M25 junction 28 improvement scheme

TR010029

9.55 Written submission of Applicant's case put orally at Issue Specific Hearing 1 on Environmental matters held on 3 and 4 March 2021

Client		Project		GROVE FARM ACCESS, JUNCTION 28 M25 NORTHBOUND SLIP LANE	
MR L JONES & MRS K JONES		Title		ACCESS ALTERATIONS TO GROVE FARM	
Status	Drawn	Scale	Sheet Size	Date	Drawing No.
FOR APPROVAL	PL	1:1000	A3	JAN 2021	REDW-3396-110
				Rev

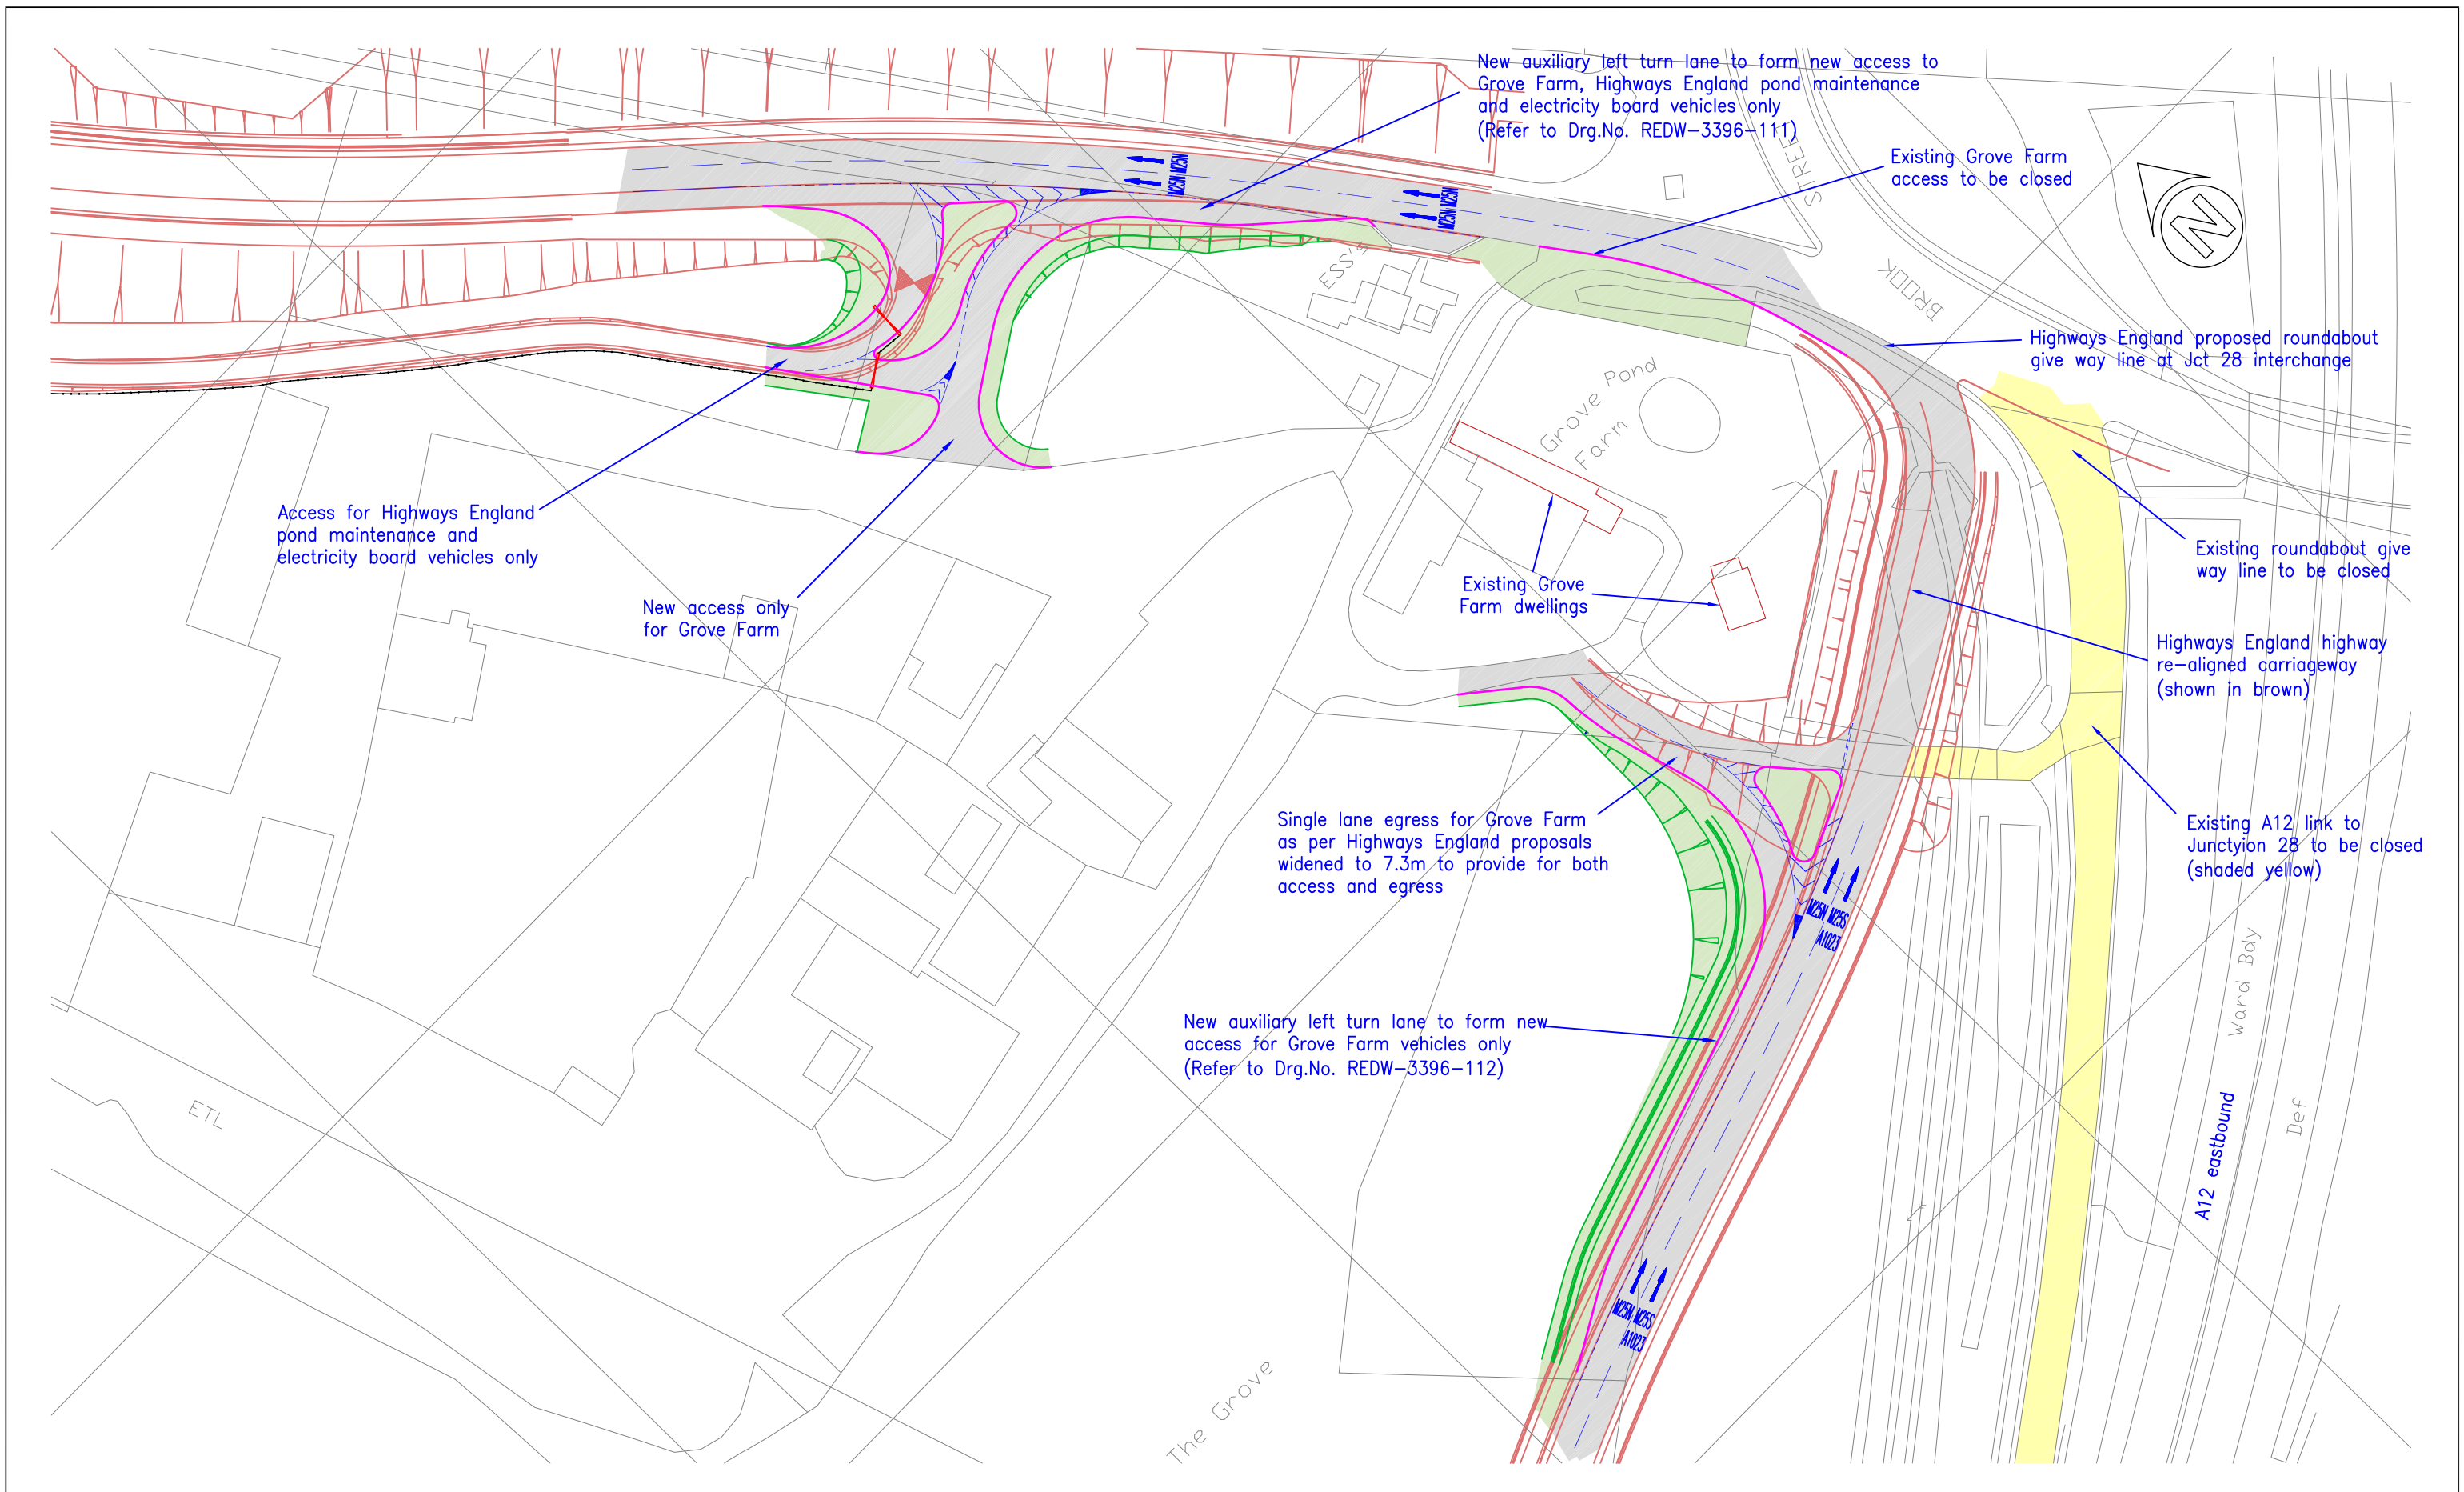
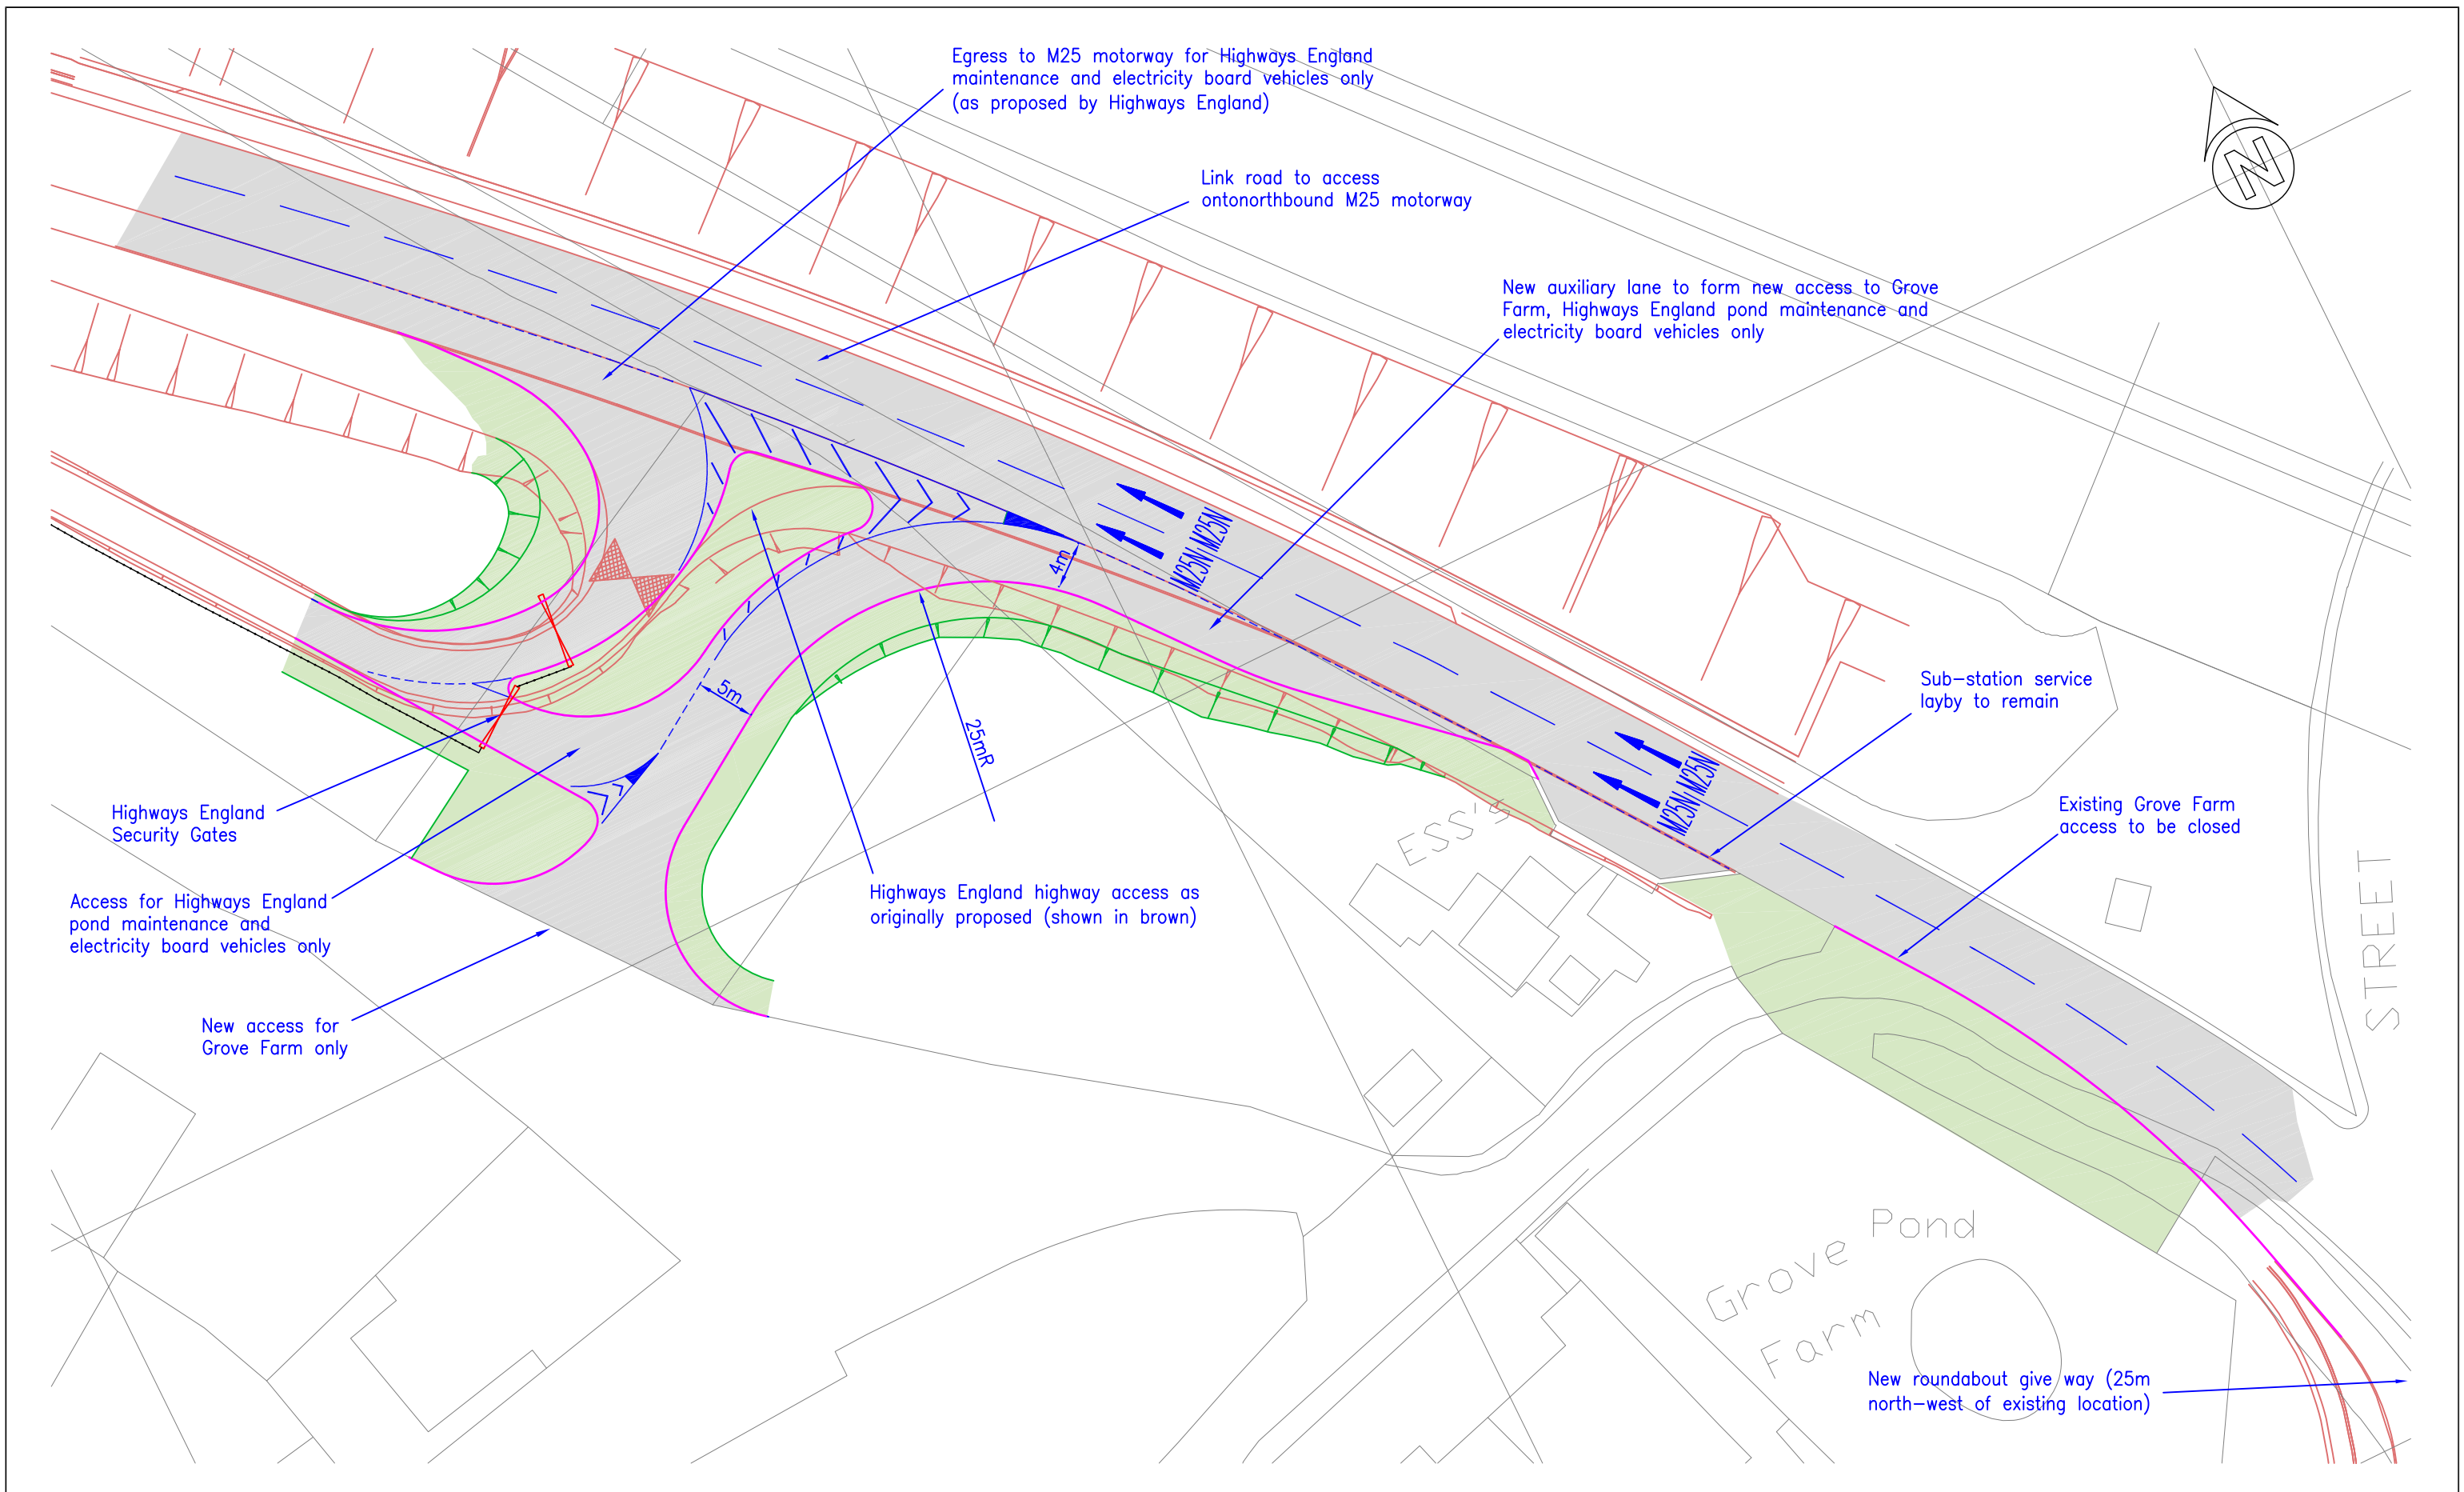
Agenda item 2.6 - Suggested alterations to proposed access to and egress from Grove Farm prepared by representatives of the Jones Family submitted at Deadline 2 [REP2-033].

- 3.1.59 Relocating the ingress further north along the M25 on-slip road places it where highway vehicles are accelerating towards the merge with the M25. SH explained that Highways England's road safety and operational safety specialists had raised concerns that such a relocation would be unsafe as vehicles braking to enter Grove Farm may cause collisions with vehicles accelerating to the M25. They also raised concerns that vehicles may exit Grove Farm via the ingress and turn right onto the slip road resulting in head-on collisions.

- 3.1.62 SH explained that a new ingress from the A12 would introduce an additional movement. This would create further hazards for through traffic as vehicles brake for the diverge where slip road traffic is travelling faster being further way from the stop line. This level of provision for a private access could also be confused with the M25 on slip. SH noted again that the Highways England's road safety and operational safety specialists have raised concerns that such a provision would be unsafe.

- 3.1.63 SH acknowledged that TfL had stated this and confirmed that direct accesses on slip roads are not permitted in the design standards. They would be departures from standards. Operational safety would be a material consideration in the departure approval review

- 3.1.64 SH concluded that moving the revised access from the M25 slip position as proposed by Grove Farm is less safe because vehicles are increasing their speed to merge with the M25. The existing access is close to roundabout so vehicles would be moving slowly.
